Application no: H16-0663-15

Description: Details of lighting, archaeological report, foul and surface water disposal, landscaping boundary scheme and provision of passing places and structural repair to work to Drain Bank North (Conditions 6, 7, 8, 9 and 10 of H16-1003-13)

Location: Land off Drain Bank North
Spalding

ACKNOWLEDGEMENT OF AMENDMENT

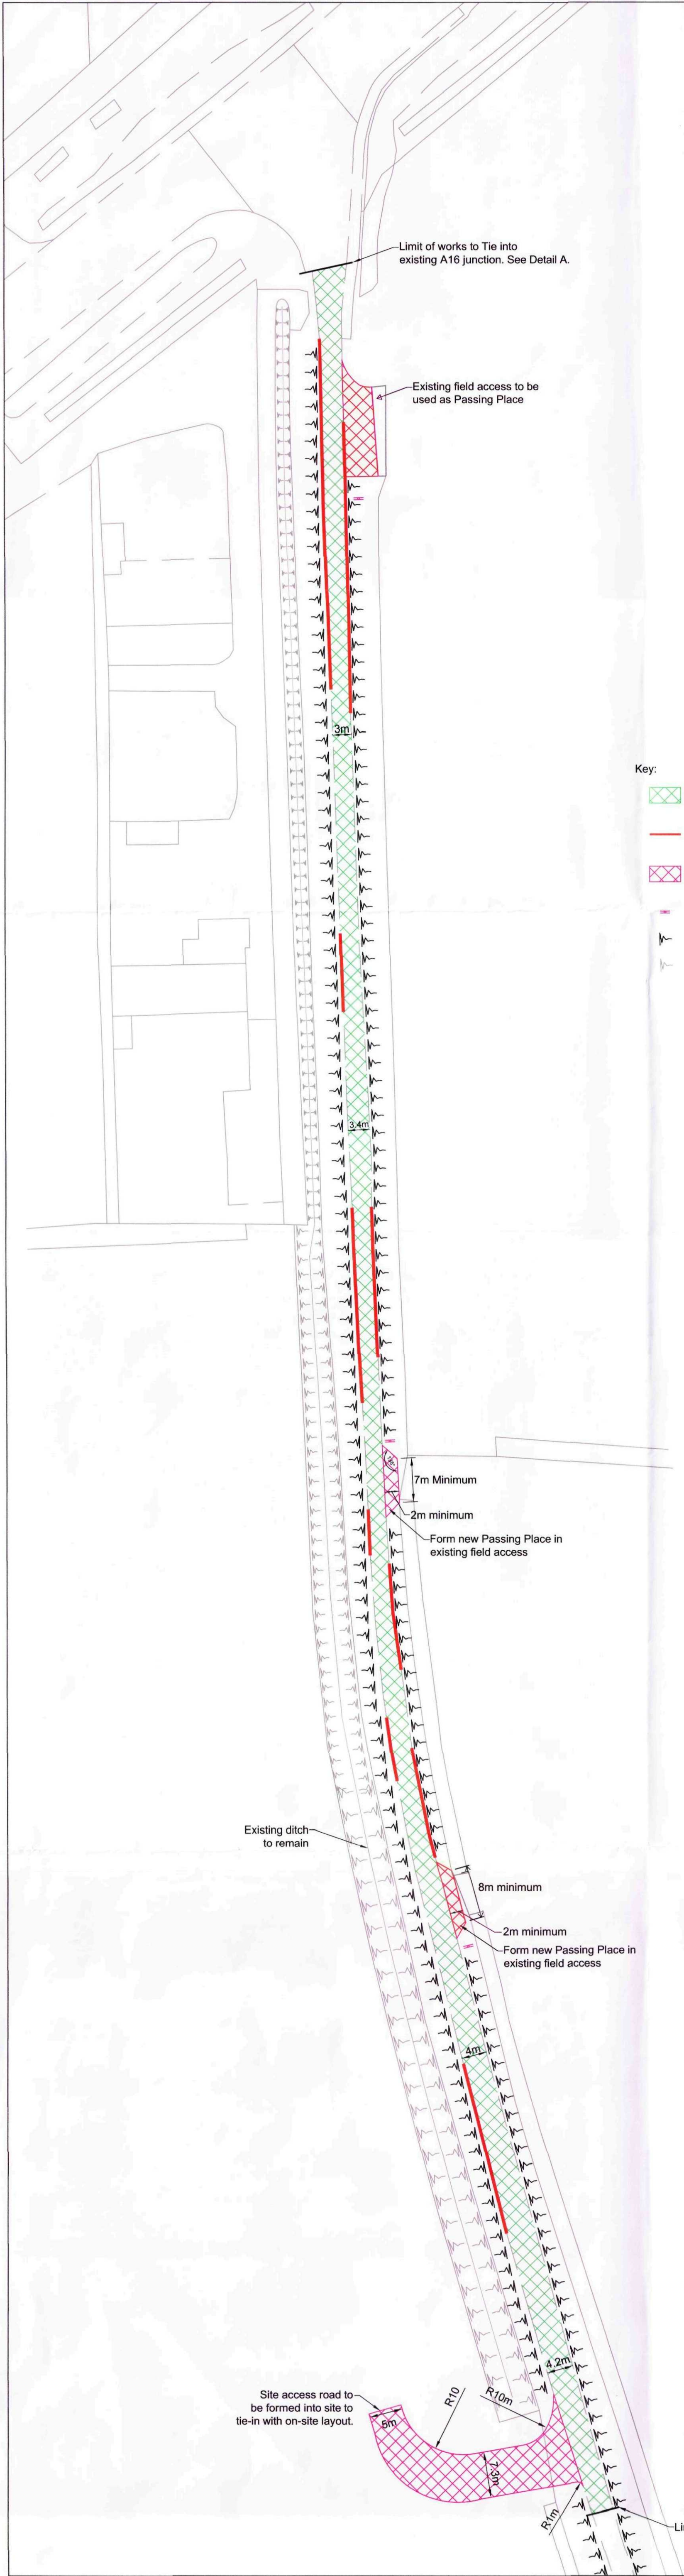
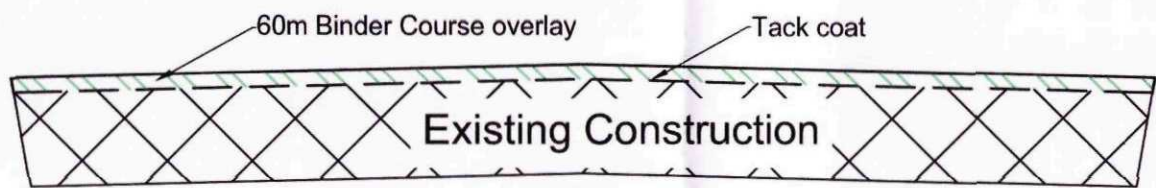
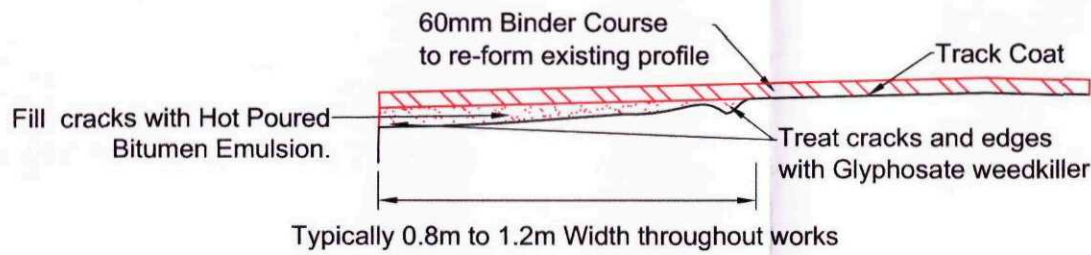
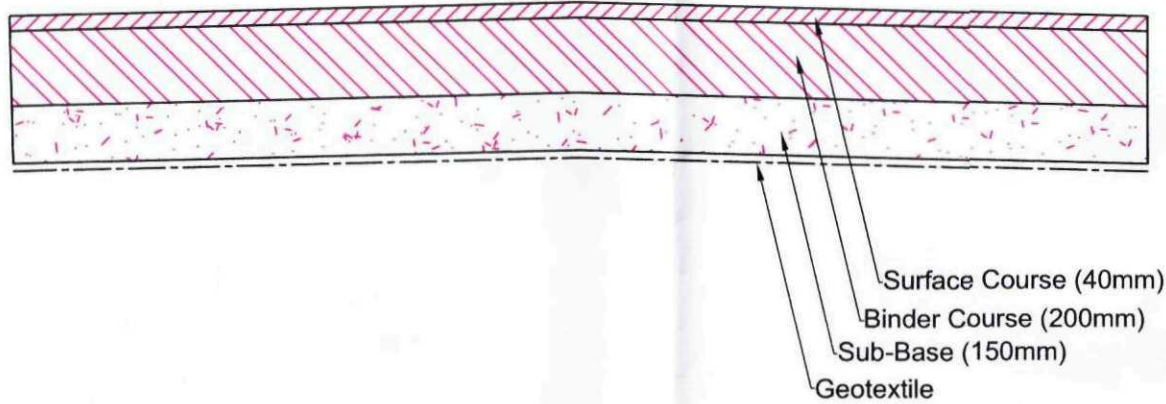
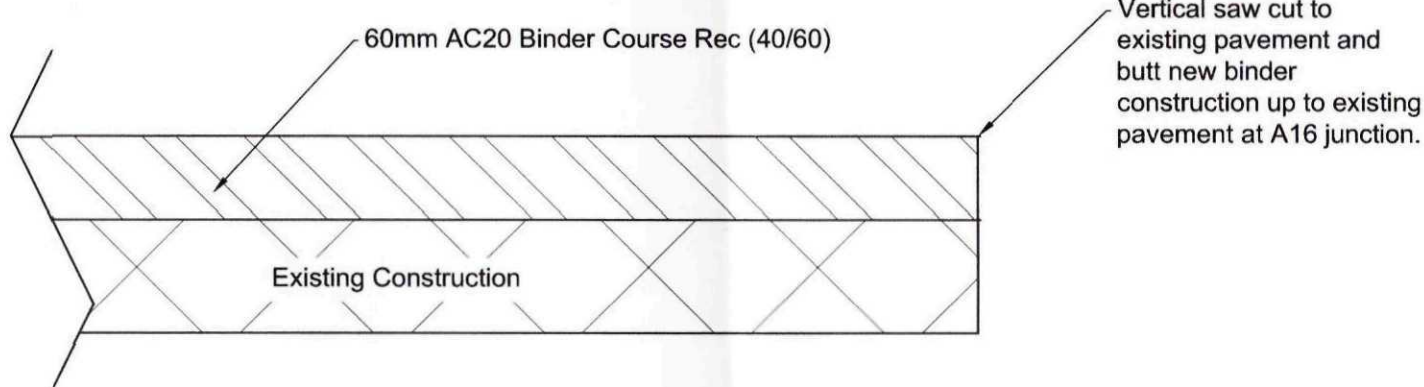
Amendment: Passing places have been moved back to fall inside the public highway (dwg. no. JN1751-NWK-001C)
